05 October 2020
Ref: RH/Let/P1456i

Discharge of Conditions 6, 21 and 22 pursuant to application reference A/51/14/OUT (*Outline Application with Some Matters Reserved for demolition of the existing Manor Nursery Garden Centre and hard standing and redevelopment for 32 dwellings with associated access, public open space and landscaping*) at Manor Nursery, High Street, Angmering, BN16 4AW.

Appendix B – Email Correspondence with Arun District Council dated August 2020

CLIENT Roffey Homes Ltd	
PROJECT Manor Nurseries Site Angmering	
TITLE Proposed Maintenance Ownership Plan	
DRAWN P Reynolds	DATE Dec 2020
ENGINEER S Burgess	CHECKED
SCALE 1:250 @ A1	PROJECT NO. 22995 Dwg. No. REV. 120

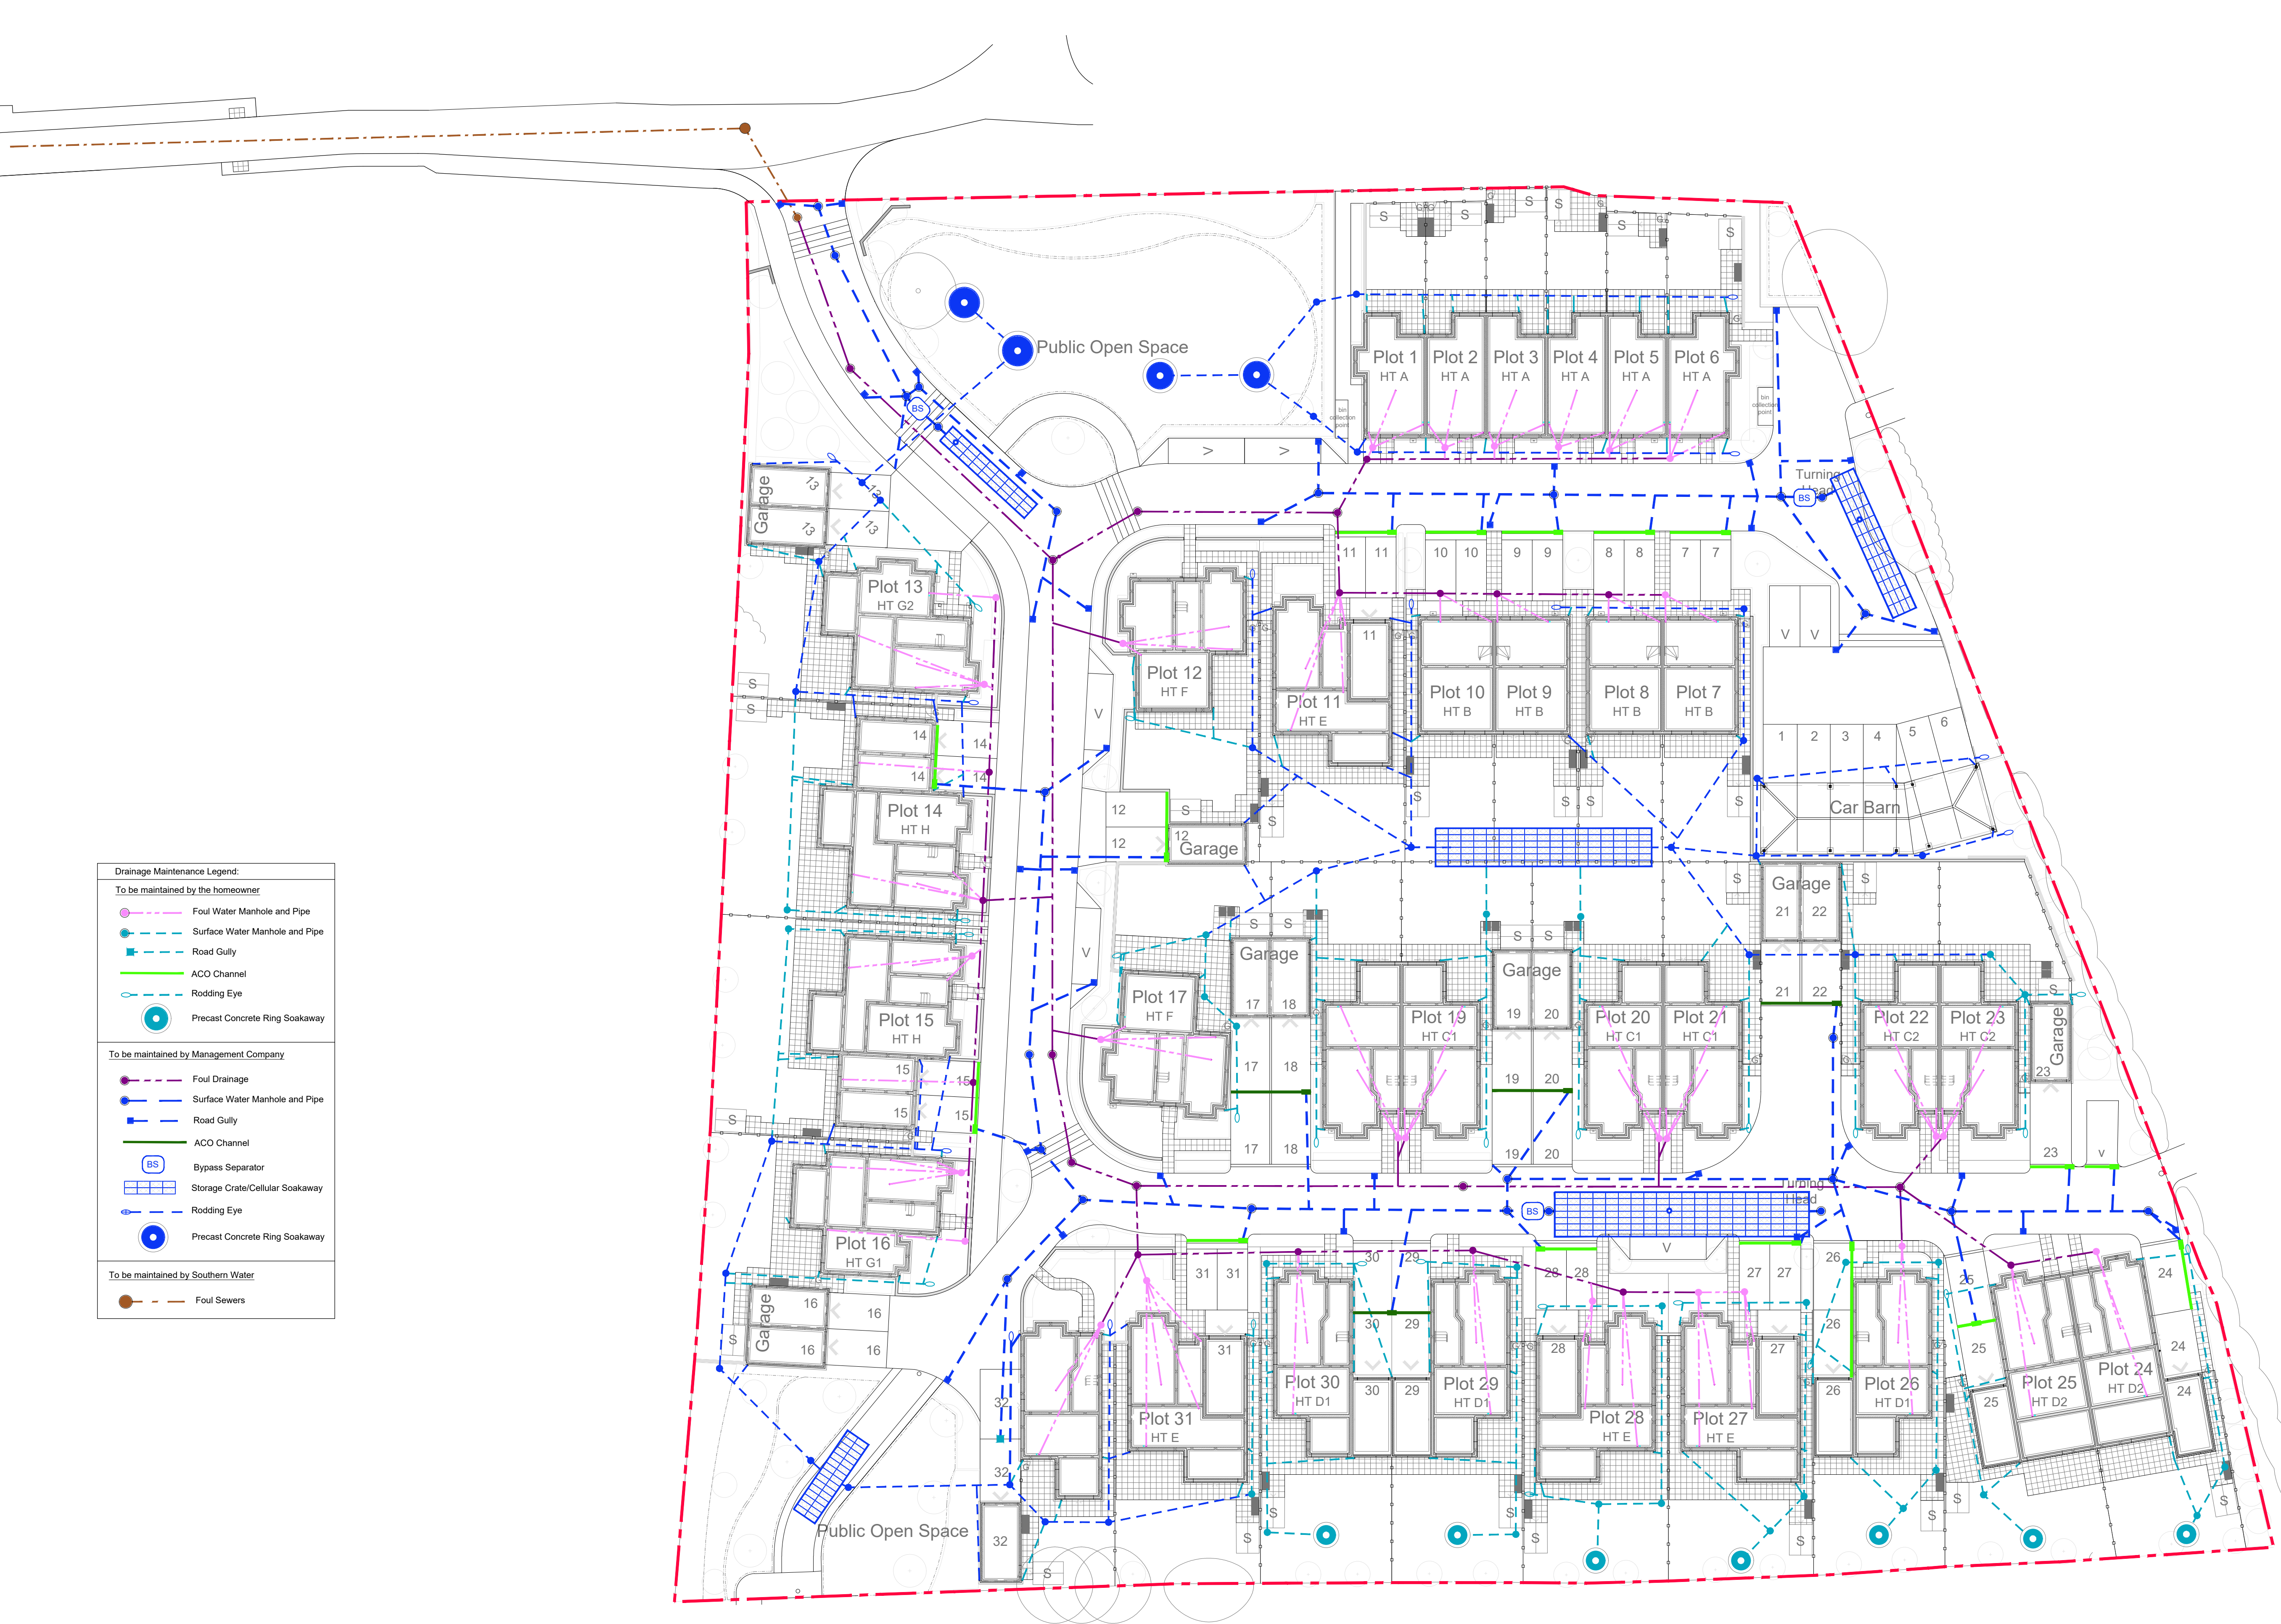
We will require further information on how adequate treatment of surface water is occurring prior to discharge to ground in accordance with chapter 26 of CIRIA C753. There is no evidence of any pollution mitigation prior to discharge to soakaways. This is a particular concern regarding water from highways where pollution hazard indices are higher.

It is not appropriate to review this condition until the drainage design is agreed.

Within the email correspondence under section (3), further information has been requested as to *'how adequate treatment of surface water is occurring prior to discharge to ground in accordance with chapter 26 of CIRIA C753'*. As illustrated within the accompanying Drainage Layout Plan (reference 102 rev D), Bypass Separators are proposed within various positions in the site. These are considered to be adequate in this instance.

With regards to the SuDS Maintenance Plan, as noted in the attached email correspondence at Appendix B, this will be updated once the surface water drainage strategy and design for the site has been agreed.
